From: Anita Gardner
Sent: 26 July 2011 12:24
To: 'roger harden'
Subject: RE: Wandleys Farm, Walberton WA/32/11/DOC

I have received your revised landscape plan today. Please can you confirm the pot sizes/height of the proposed plants.

SITE PLAN 1:100

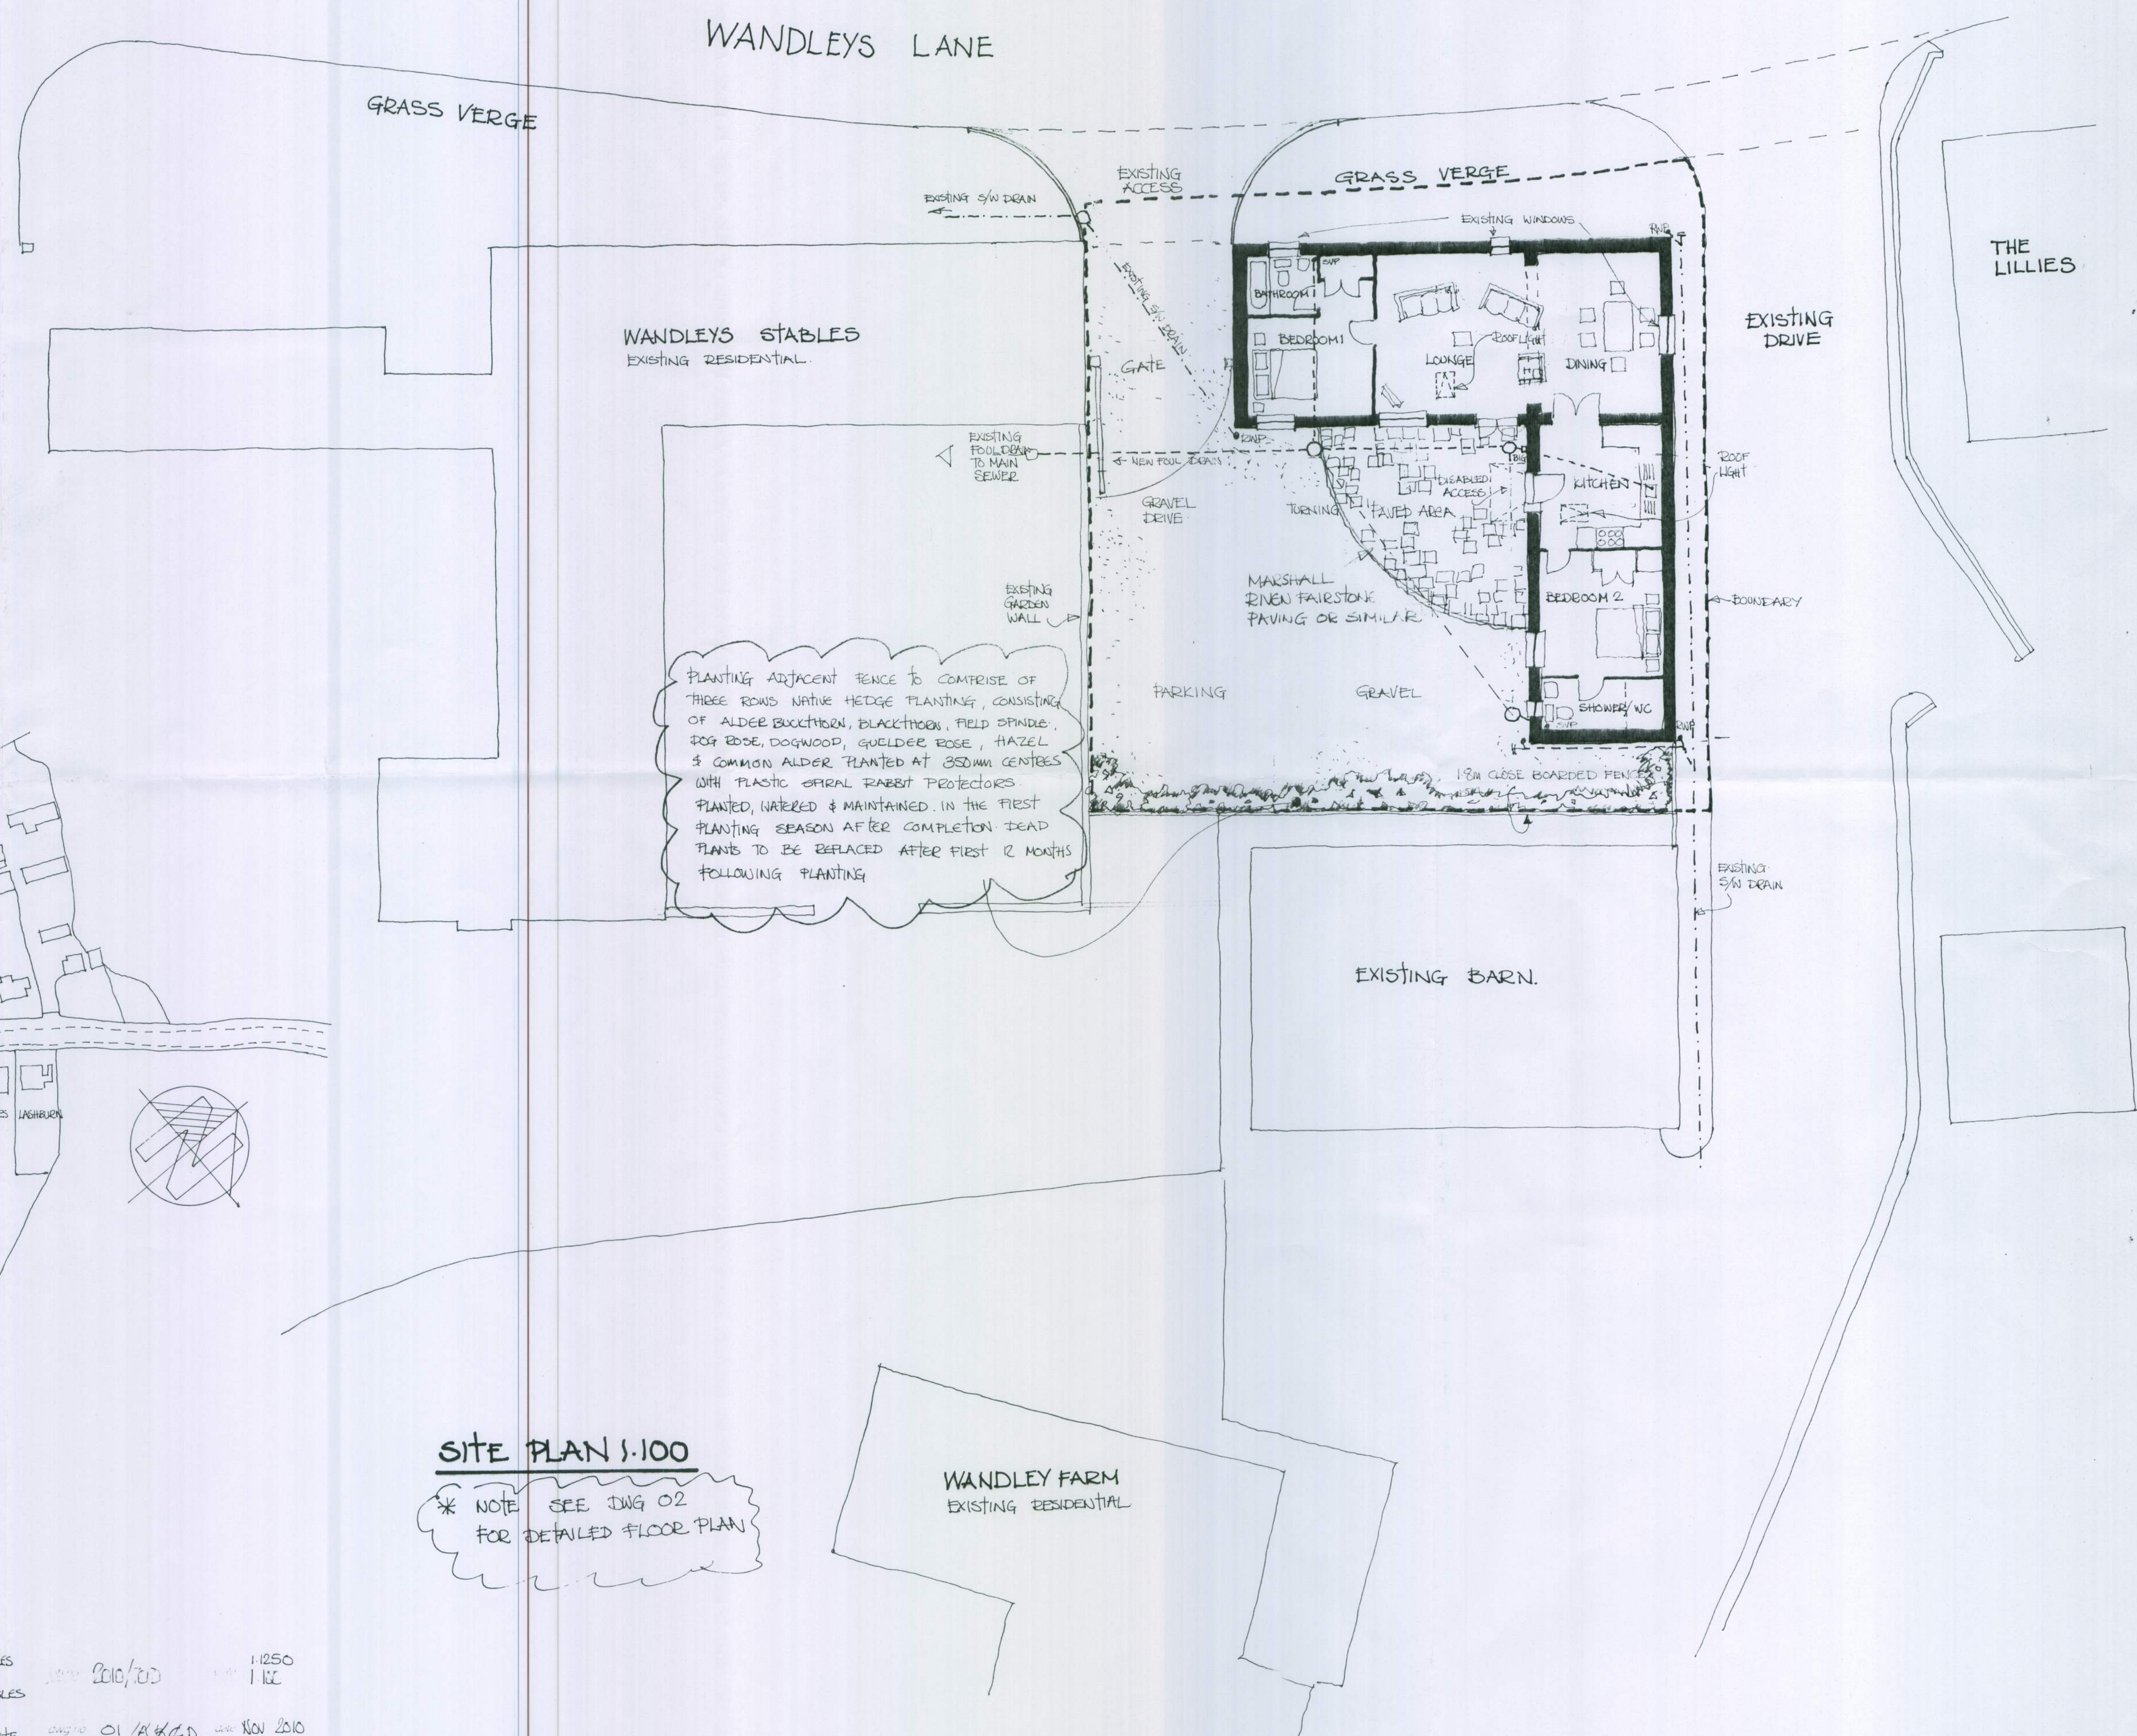
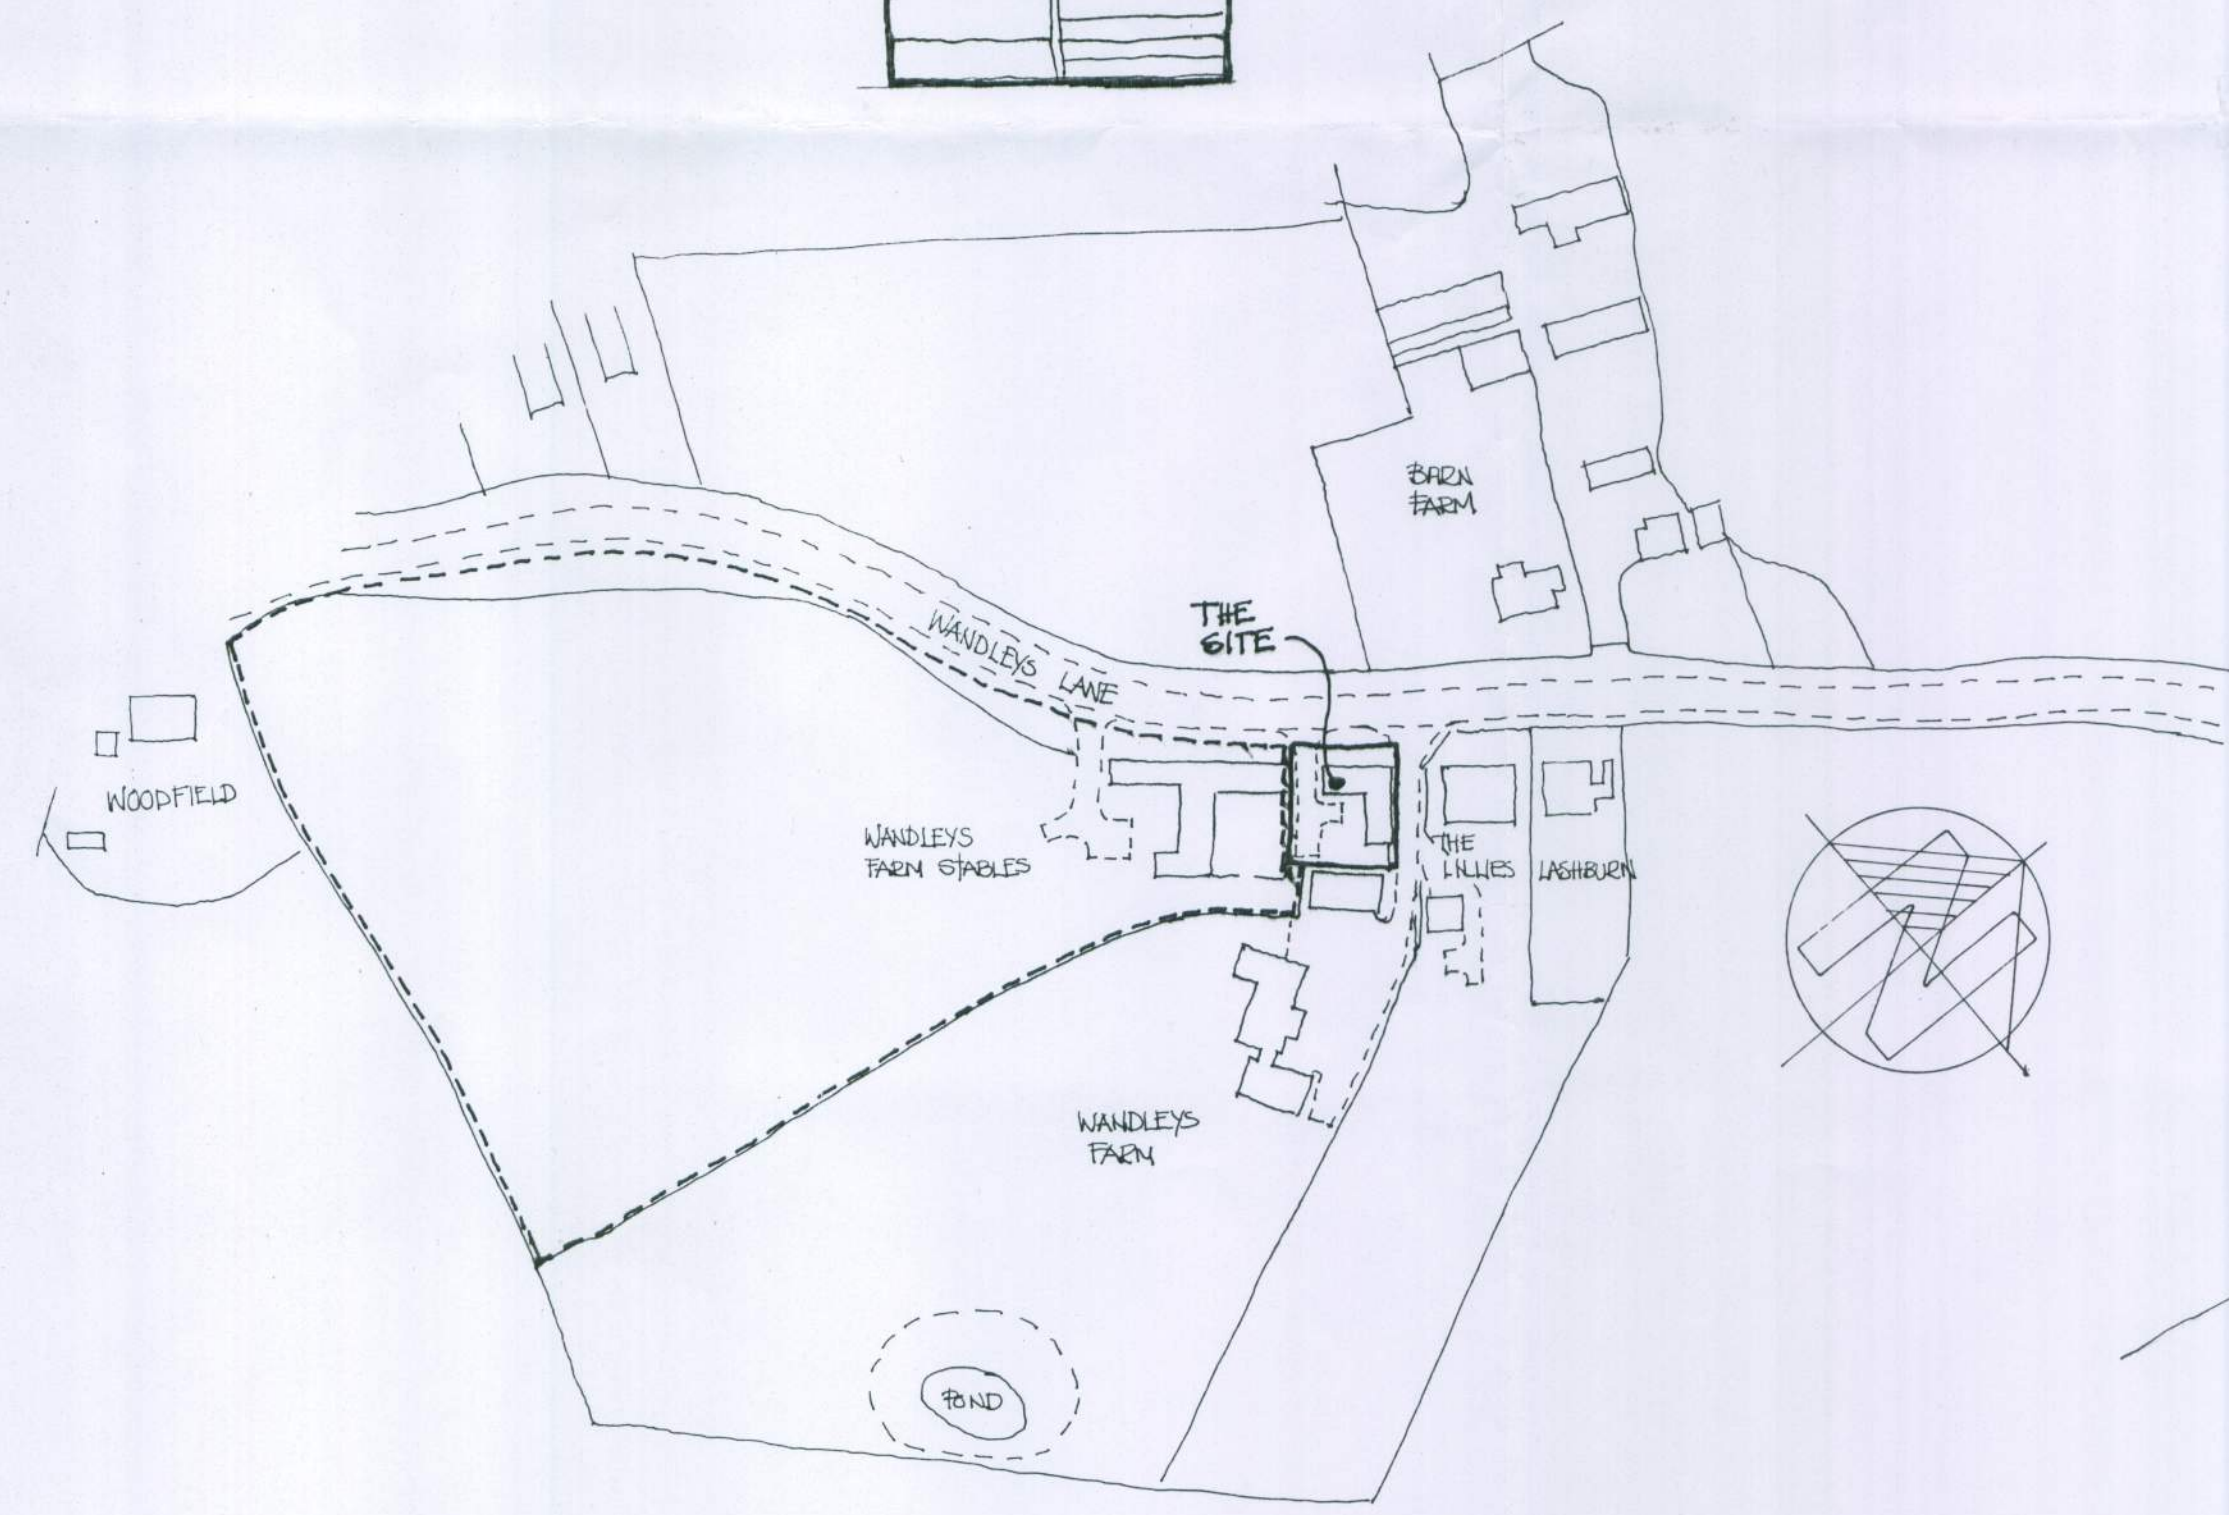
Roger,
 Thankyou for your prompt response. I don't need to know the anticipated plant heights. I need confirmation of the sizes when planted in order to ensure that they will fill the space adequately and stand a chance of establishing relatively quickly.
 Thanks
 Anita

Thank you for your e-mail. The maximum growth heights in hedge varieties of the plants listed are as follows,

Dog Rose, Dogwood, Guelder Rose, up to 750mm

Field Spindle, Blackthorn, Buckthorn, up to 2m in height

Alder & Hazel up to 3m in height
